Final Acceptance (FA) Punchlist
EPC - DPW - Stormwater Section

Project Name:	Lorson Ranch East F1
EDARP Filing Number(s):	SF188, CON1958
ESQCP Number:	ESQ182
Attendees:	DPW SW: Natasha Grimaldo, Ben Jones Stormwater Engineers: Mikayla Hartford and Glenn Reese walked the site on 2/28/2023. Developer: John Chavez
Date of Walk-Thru:	2/14/2023
Walk-Thru Number:	1 st

Findings to be addressed prior to scheduling a follow-up walk-thru:

POND C5  
FOREBAY 'A' AND 'B'  
LAYOUT AND DETAILS

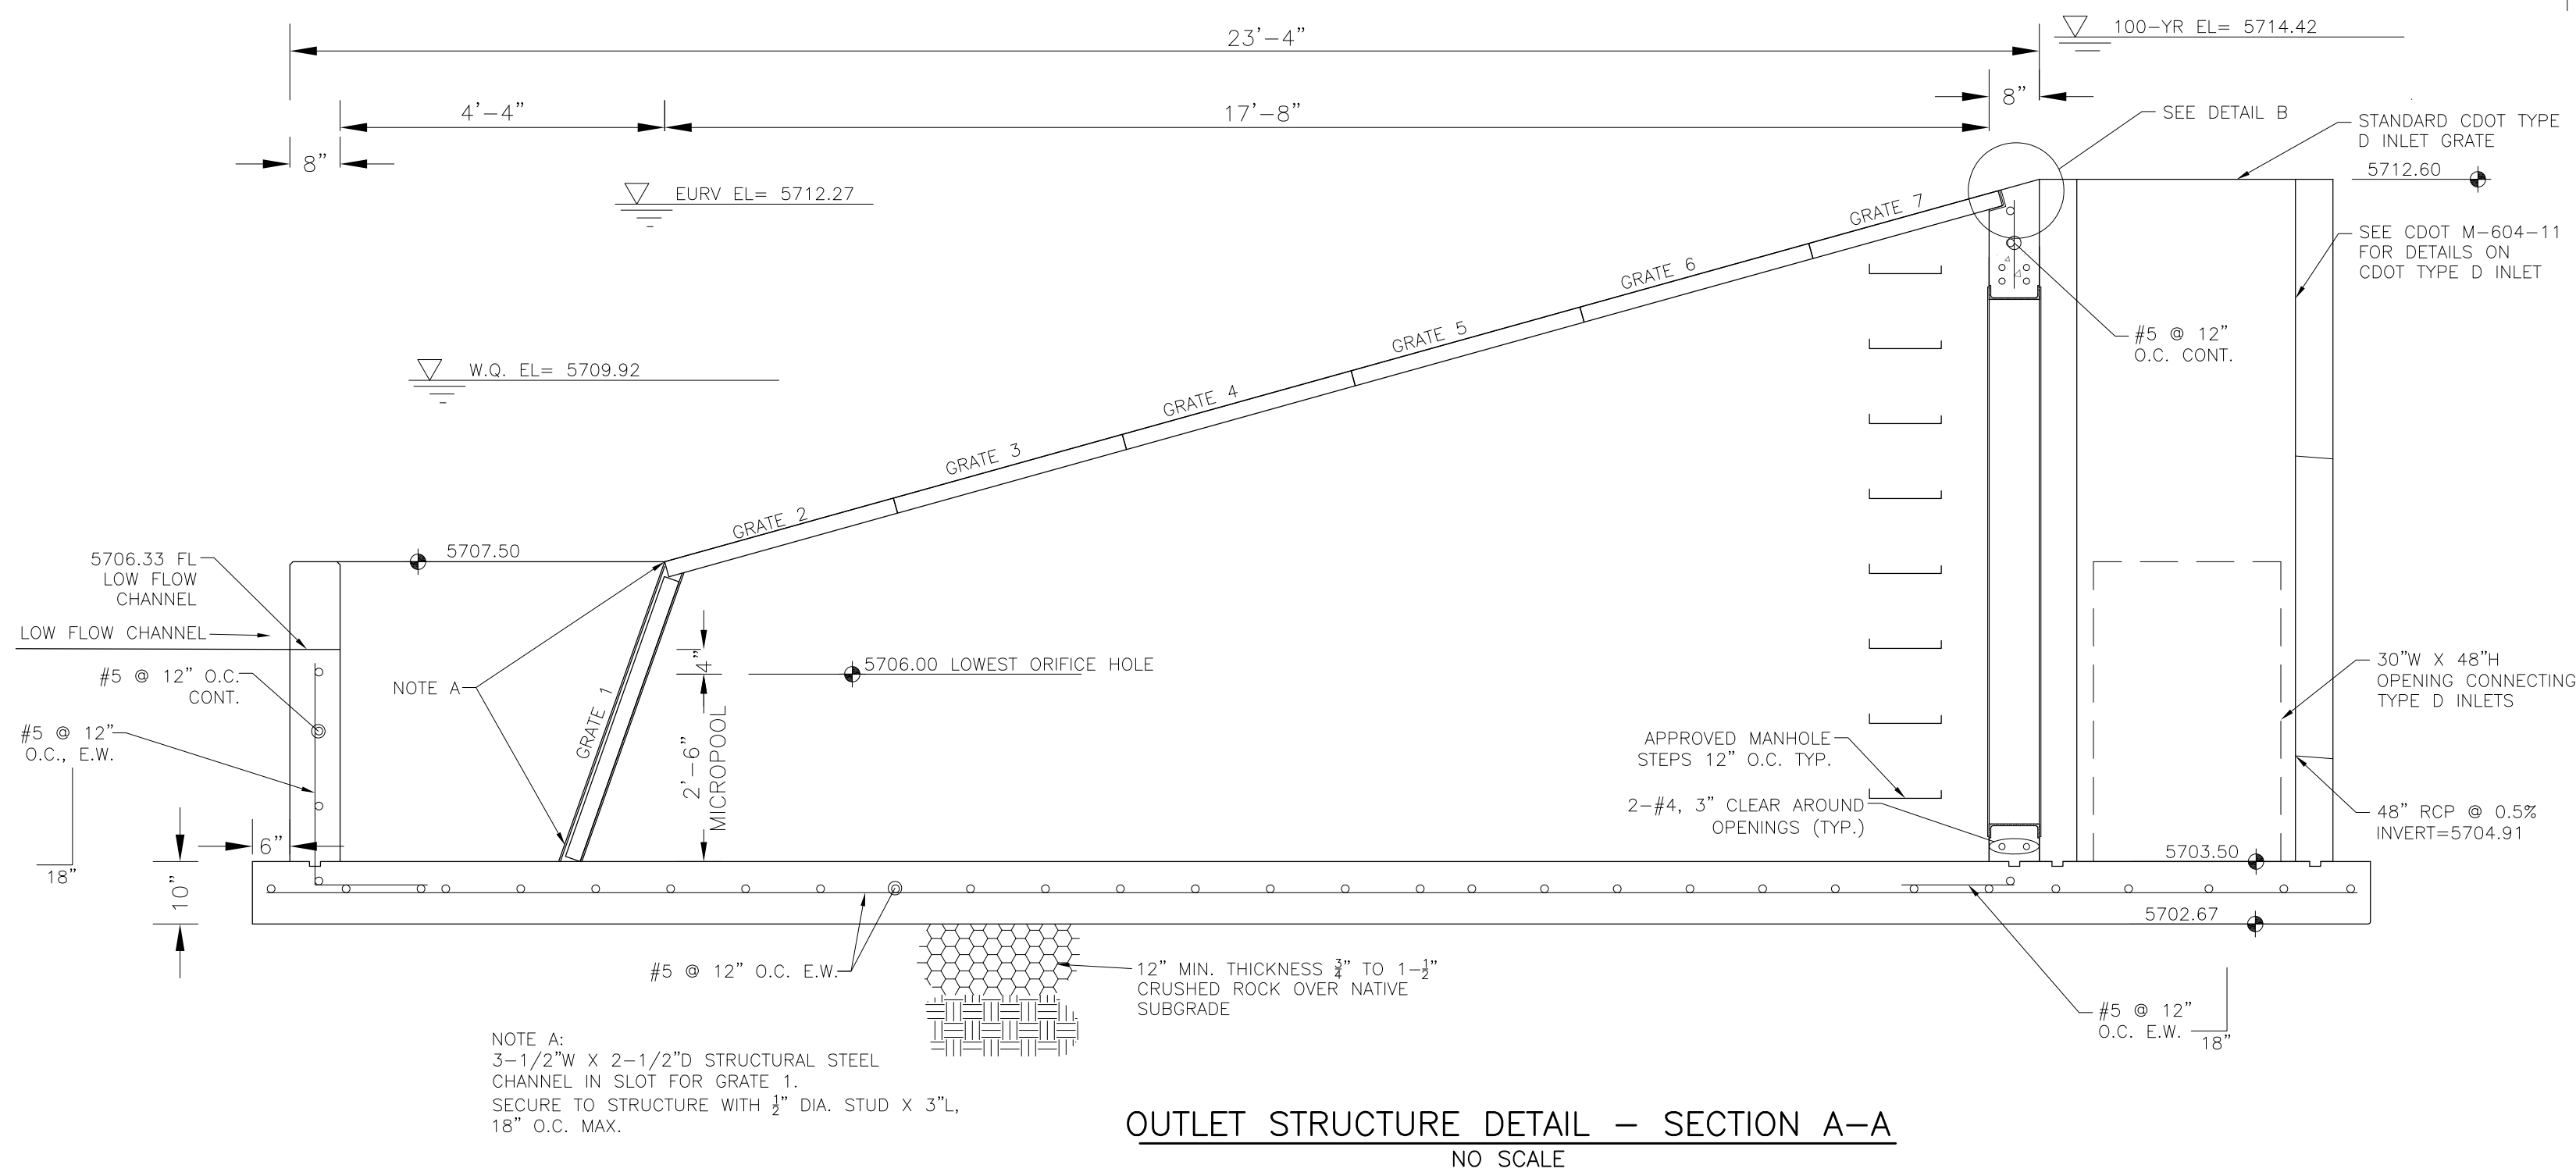
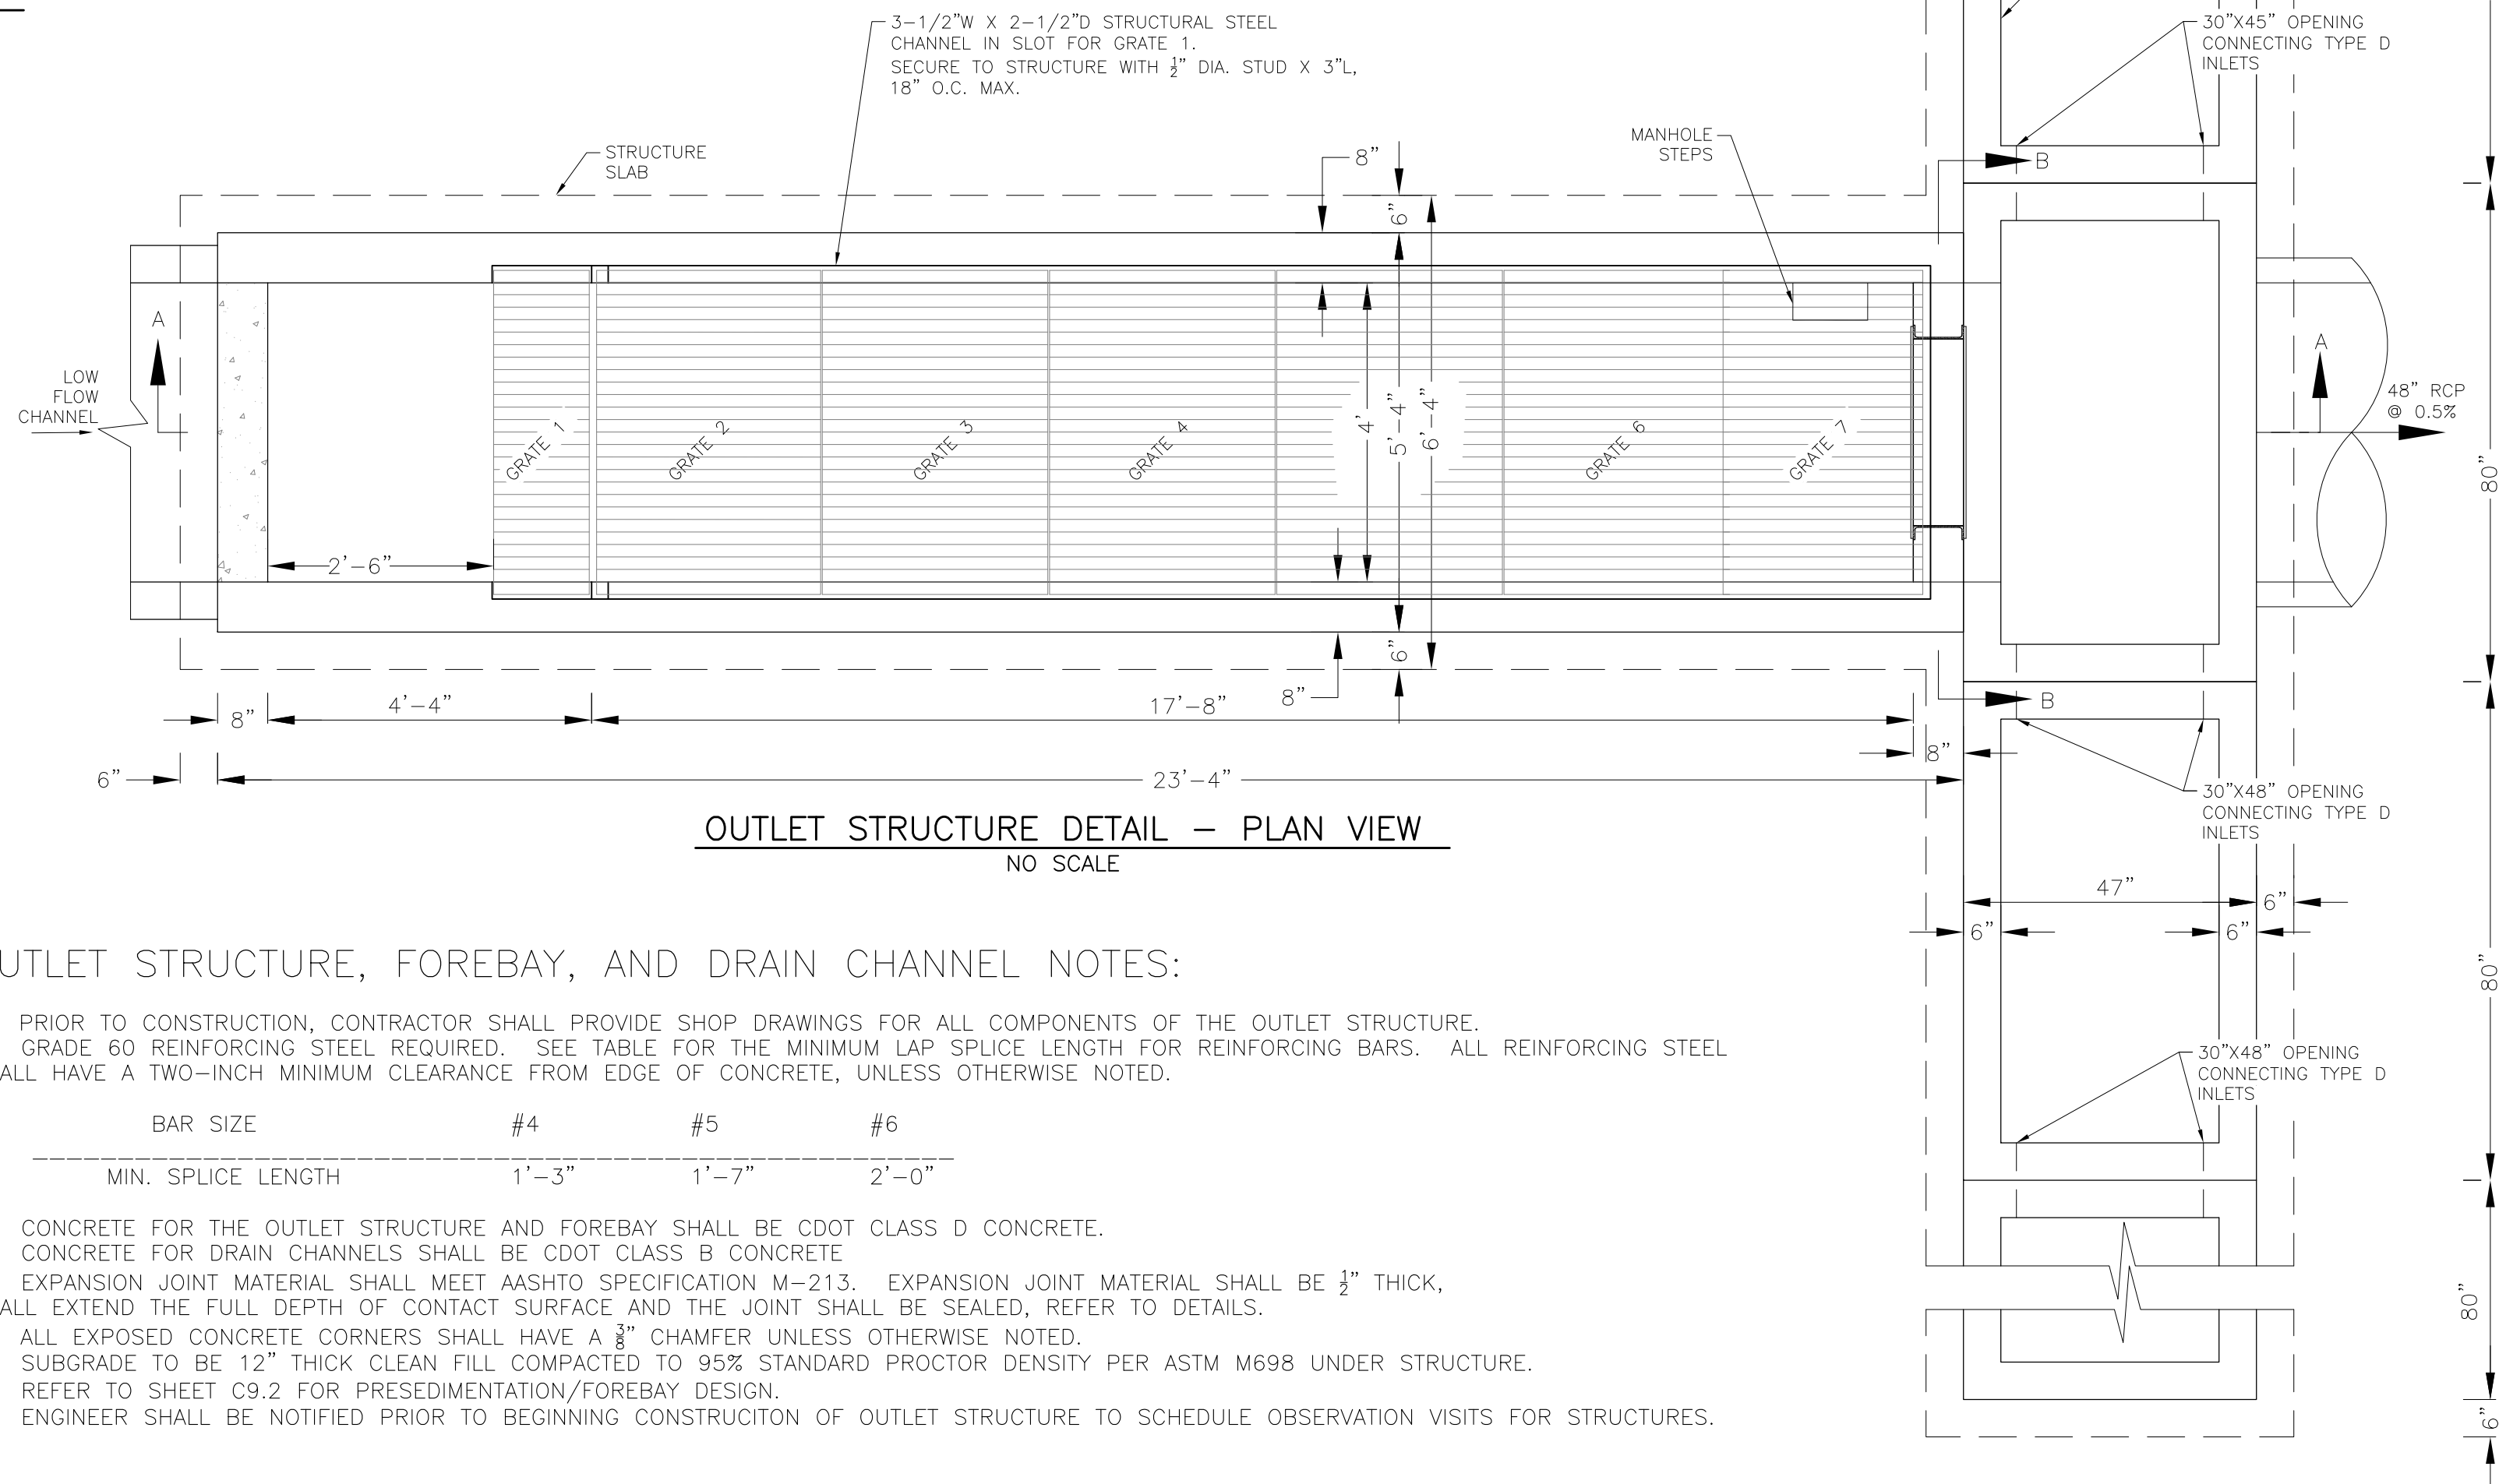
- Remove sediment and debris from outlet pipe.
- Remove rock sock from forebay notch in forebay B.
- Implement 9" D50 rip rap per specification on forebay A and B. Reference sheet C9.2 of CDs.
